From: [Linda Legg](#)
To: [Zach Torrance-Smith](#)
Subject: re: RU-26-00001
Date: Tuesday, April 21, 2026 11:10:01 AM

In regards to the notice of application for a reasonable use application, I have a couple of concerns at this time. It is in regards to the proposed installation of a culvert crossing over the southern stream near the center of the parcel, and the proposed detached garage.

LOT 9 HYAK ESTATES 2 GRADING DESIGN
RYAN PAZARUSKI
SITE PLAN

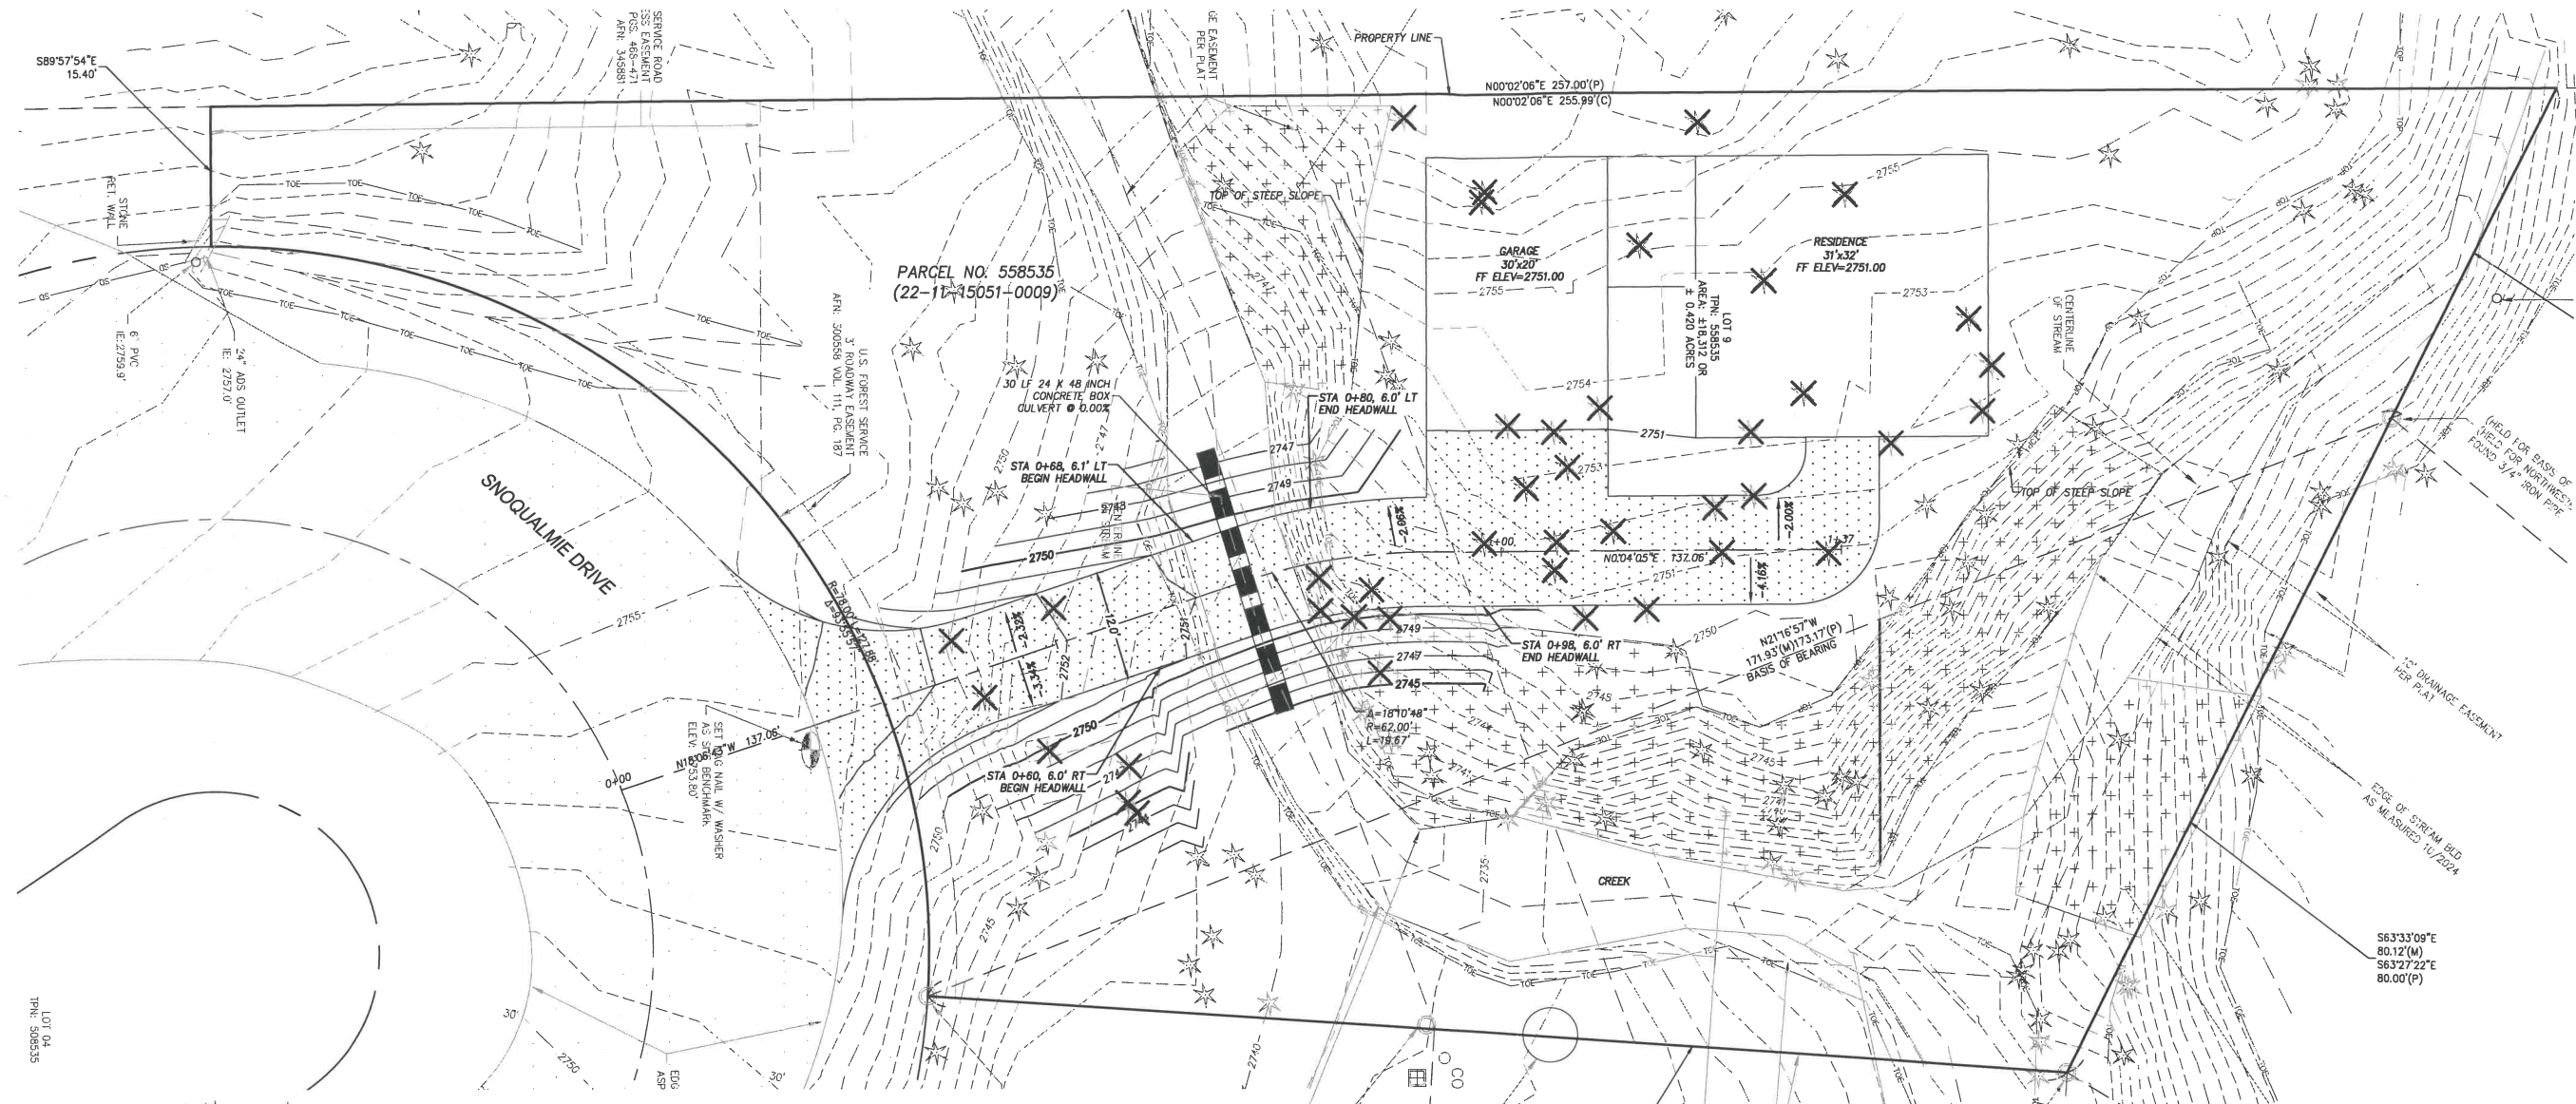
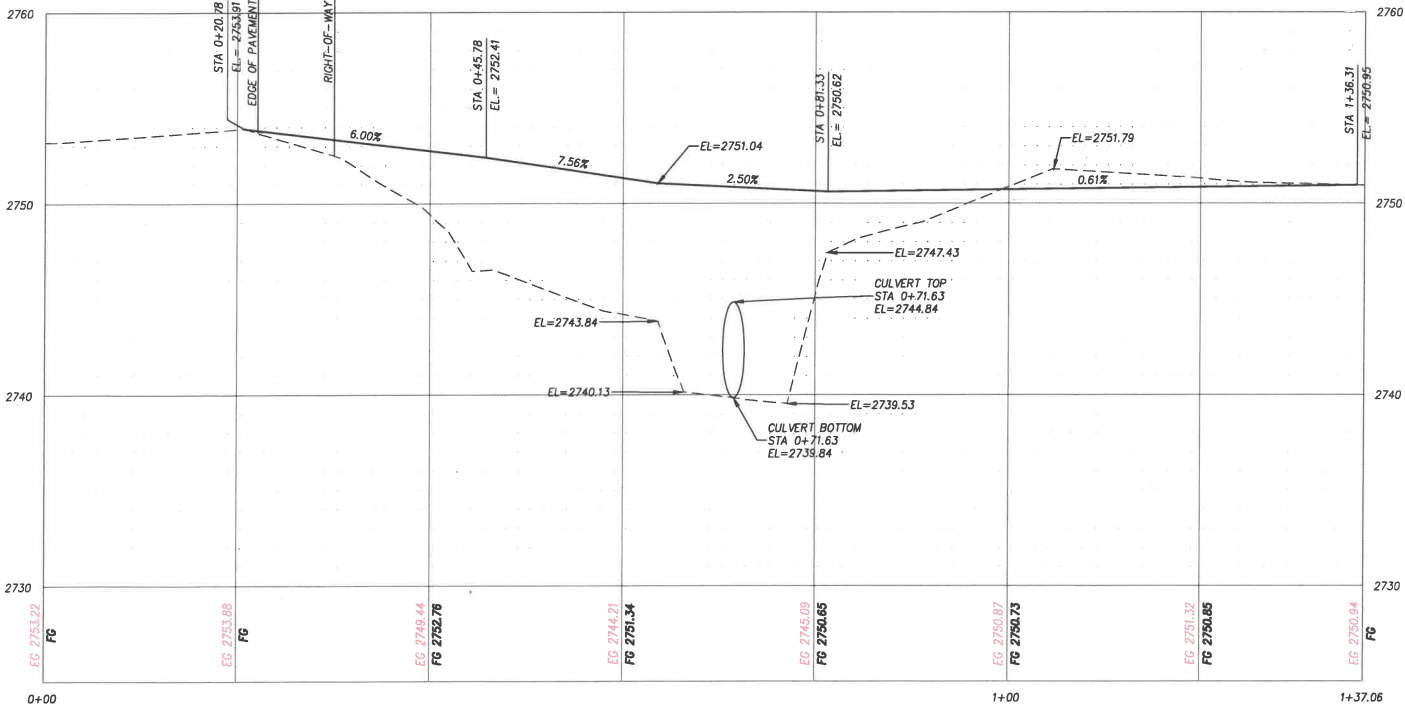
RE: Culvert - Nowhere in the documentation that I have been able to find, are any indications of the size of this culvert. It is only mentioned that "The proposed culvert crossing will be designed and installed in accordance with applicable engineering and environmental standards to ensure proper drainage and maintain stream function." (as stated on the Pazarusk narrative owner statement).

The property owner further states in his narrative "The proposed *drainage* crossing has been designed in a manner consistent with other crossings present within the Hyak neighborhood...". First, this is a stream not a drainage. Second, with this winter's heavy rains and melt off that caused massive flooding at the entrance to Hyak neighborhood, seriously damaging that road bed, I do not feel that serious consideration is being given to this issue aka the owner in his statement dumbing down a free flowing stream to just a drainage crossing"

RE: Detached Garage - it is stated in this same document that " The proposed single-family residence and detached garage are consistent with the residential zoning designation for the parcel and with the surrounding pattern of development within Snoqualmie Pass". I have consulted with our HPOA President and she confirmed my belief that detached garages are not allowed under the covenants for the Hyak neighborhood. I am assuming that this issue can be further discussed with the HPOA board to come to an equitable resolution.

My intention with my comments is not to halt a new neighbor from utilizing the lot they own, but to ensure that the stream crossing in all seasons/weather is built in such a way that does not create damaging flooding to our current road system.
